WEST SUSSEX COUNTY COUNCIL CONSULTATION

TO:	Arun District Council FAO: Simon Davis
FROM:	WSCC - Highways Authority
DATE:	18 June 2020
LOCATION:	9 Westloats Lane, Bognor Regis, PO21 5JZ
SUBJECT:	BR/128/20/DOC Approval of details reserved by condition imposed under BR/219/18/PL for condition 4-surface water drainage; 5-colour schedule of materials & finishes, 6-dustbin enclosures details; 7-electrical vehicle charging points, 8-incorporation of decentralised, renewable, low carbon energy supply system, 9-vehicular access details & 11-cycle parking space details.
DATE OF SITE VISIT:	n/a
RECOMMENDATION:	Advice
S106 CONTRIBUTION TOTAL:	n/a

This application seeks discharge of condition 4, 5, 6, 7, 8, 9 and 11. Conditions 4, 5, 6 and 8 relate to non-highways considerations and as such no highways comments will be provided.

Project
 Proposed Site Plan
 Date
 2nd May 2018
 Scale
 1 : 500

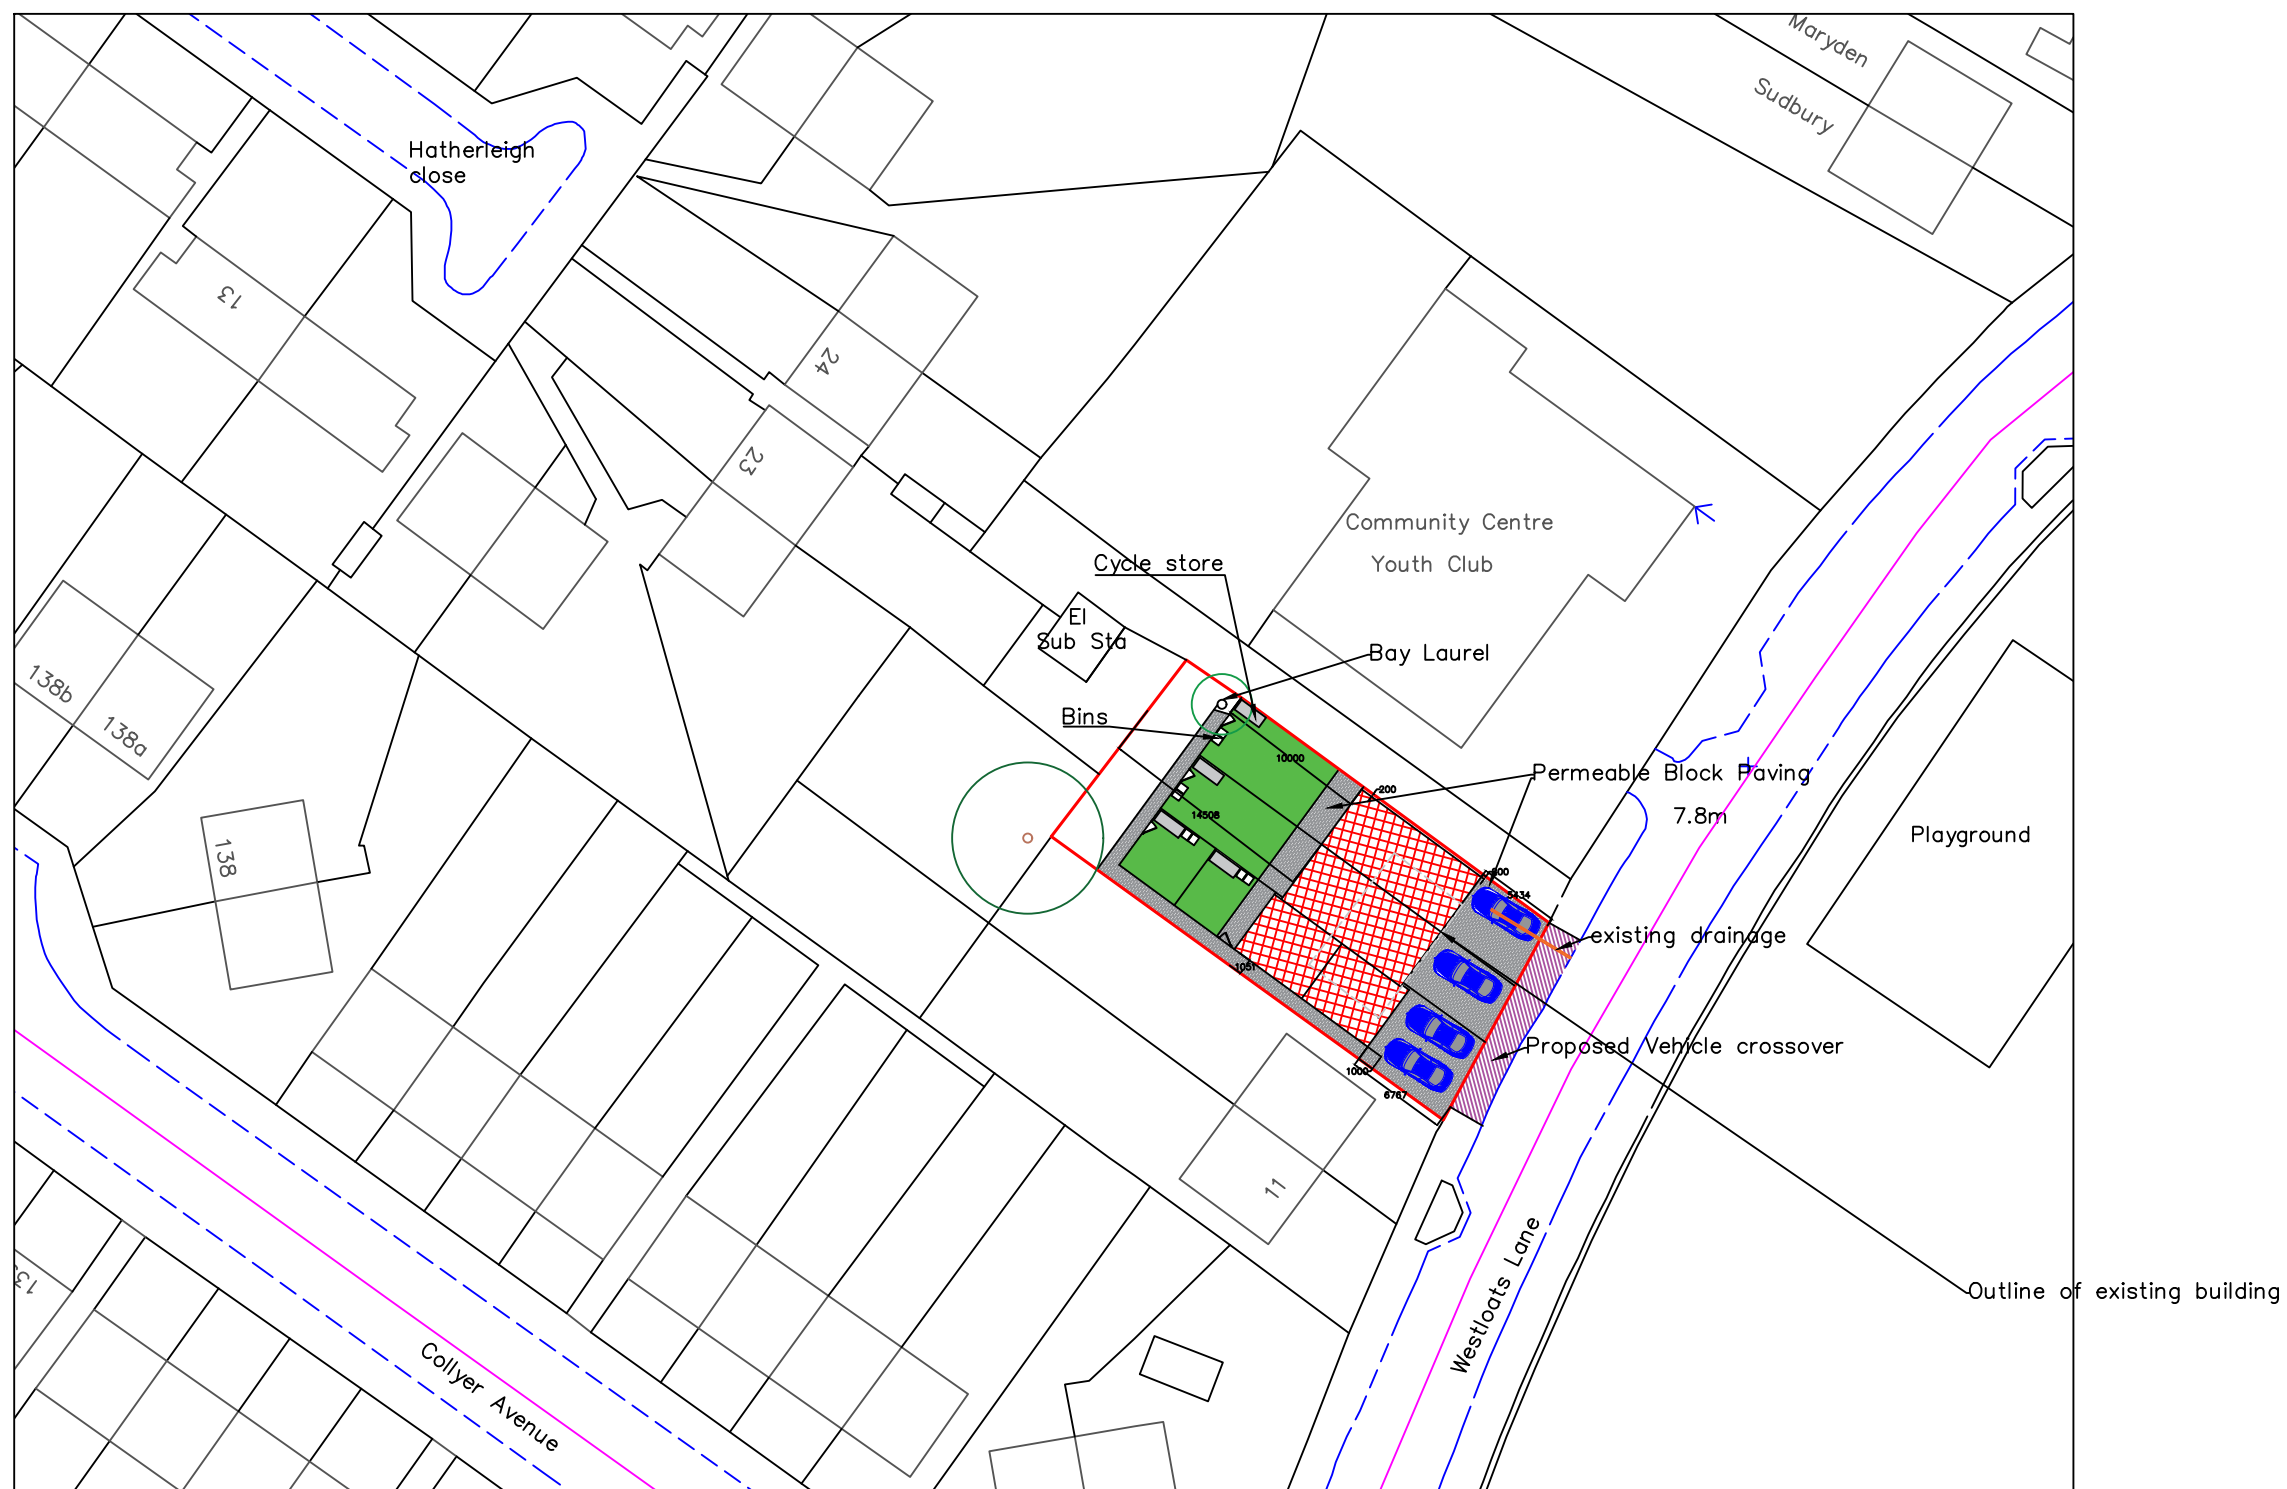
The applicant has submitted details of the charging sockets to be installed and has separately stated that each dwelling will be provided with a charging point, although the location of these has not been demonstrated on the proposed site plan.

The LHA is satisfied with these details - the LPA is advised to ensure that the charging sockets meet the necessary standards for electric vehicle charging and is also advised to consider whether the proposed location of chargepoints is required to be demonstrated on the site plan in order to fully satisfy this condition.

The submitted site plan indicates that a vehicular crossover (VCO) of approximately 13.8m width will be provided for the proposed four dwellings. The LHA is satisfied with the proposed width and details provided. The applicant is reminded that the VCO is subject to licence from the West

Sussex Area Engineer and must be constructed to a specification agreed with them. The LPA should be satisfied that the VCO has been constructed in accordance with the plan provided prior to discharging Condition 9.

The provided site plan indicates that each dwelling will be provided with a secure and covered cycle shed in the rear garden. Whilst difficult to determine from the plans, it appears that each shed is suitable to accommodate two bikes. The LHA is satisfied with the details provided for this condition.
